Re: Waterbury House, Ford, Sussex – Consultancy letter

Please find below the following heritage information and advice to assist in your design proposal and application for the construction of five flats in the grounds of Waterbury House.

This letter comes as a follow up to the letter issued on 10th December 2017, which commented on your previous design proposals. This letter now comments on revised proposals that have been made to take into consideration, comments made by the local planning authority.

2. A comparison between the 2010 approved scheme and the current proposal of March 2018

Proposed North Elevation

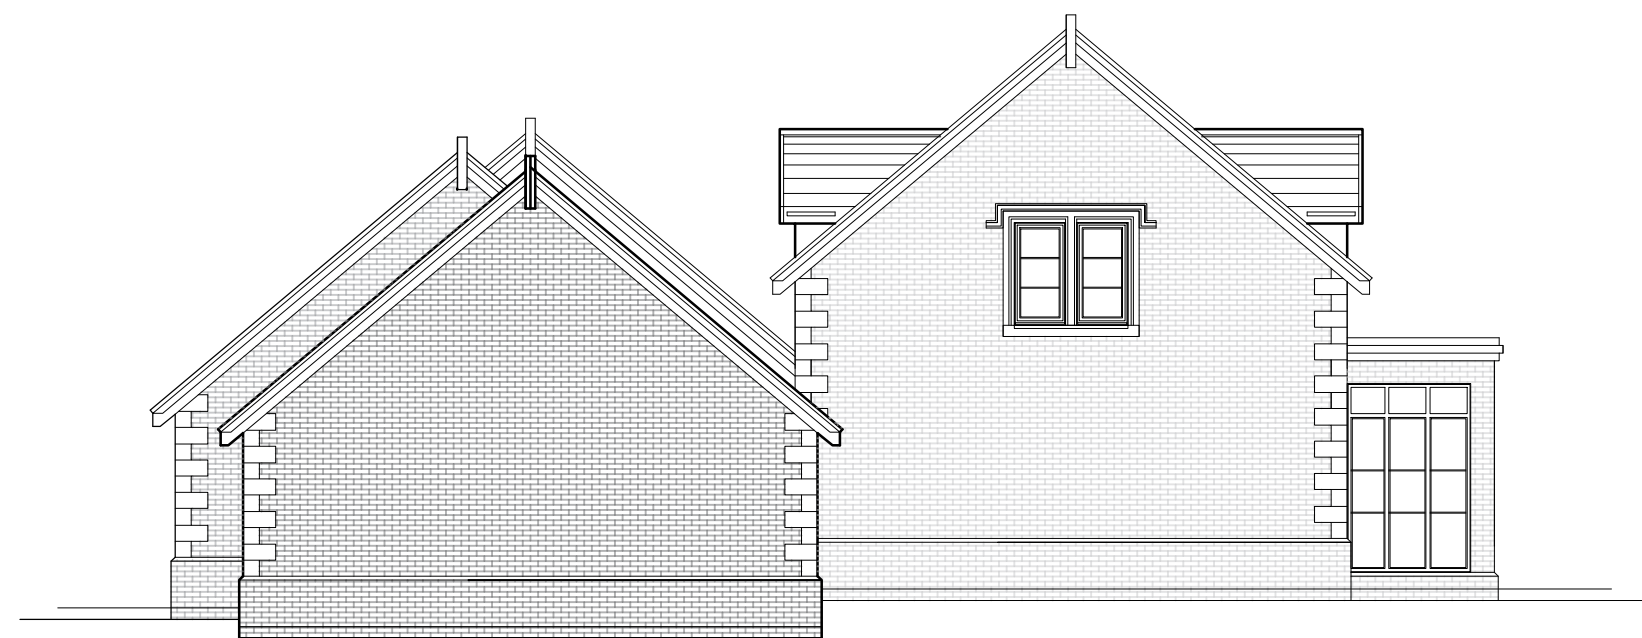
The north elevation of the proposal will be the longest elevation in total, although it is broken up into sections that are off-set from each other, to break up the elevation. The west section is in line with the south face of the main house, while the central and east sections are stepped back to the south of this. The north elevation will contain a glazed porch entrance and two gabled dormer windows on the west section that would be looking out over the garden to the east of the main house, three windows at the central section and four windows on the east section. The 2010 scheme had a long west section with four-pane windows and French windows, with an east section with a fully glazed wall facing north. The 2017 scheme had a large gabled dormer, with a long, flat-roofed dormer window and French windows. Therefore the current proposal has less dormer windows, that are smaller and would not dominate the appearance of the elevation.

The response comments on the 'bulky roofscape, comprising multiple dormer windows, with a max ridge height of 16,000 mm approx.'. The scale on the drawings had been misinterpreted, as the height of the existing building from floor to apex is 10,580 mm. The current proposal has addressed this concern, through reducing the apex roof height to 7,700 mm and thereby making the proposed building subservient to the existing building. It has also reduced the size of the gabled dormer windows on the north elevation and one on the south elevation.

The overall massing of the building of the current proposal has been articulated with a variety of rooflines and off-setting of sections to break up the footprint and elevations. The roofscape, which was quoted as 'dominant', now includes apexes of various heights that step down, as the ground level descends gently to the east of the site. In addition, the reduced size and number of gabled dormer windows will lessen the impact of the roofscape.

On the west elevation, there are three windows on the north section, together with the gabled dormer windows of the north and south elevations visible, and a south section with three windows. The 2010 scheme included one flat-roofed dormer window facing south, so it could not be seen from the house, a south section with French windows and the two sections were to be joined with glazed links. The 2017 scheme west elevation had the north and south sections adjoined, with the large gabled dormer windows of the north and south elevations clearly visible. Therefore, the current proposal has smaller gabled dormer windows by comparison.

The response states there is a 'large amount of glazed guarding visible to the west and south elevations'. The fenestration on the west elevation (numbering three windows on the north section and two windows on the south section) is markedly less than the 2010 scheme, as it avoids the glazed link sections to either side. The south elevation (numbering one dormer window and eight other windows) has significantly less glazing than the approved 2010 scheme, with less dormer windows. If 'glazed guarding' relates to glass panel fencing, then this can possibly be substituted for a more traditional fence.
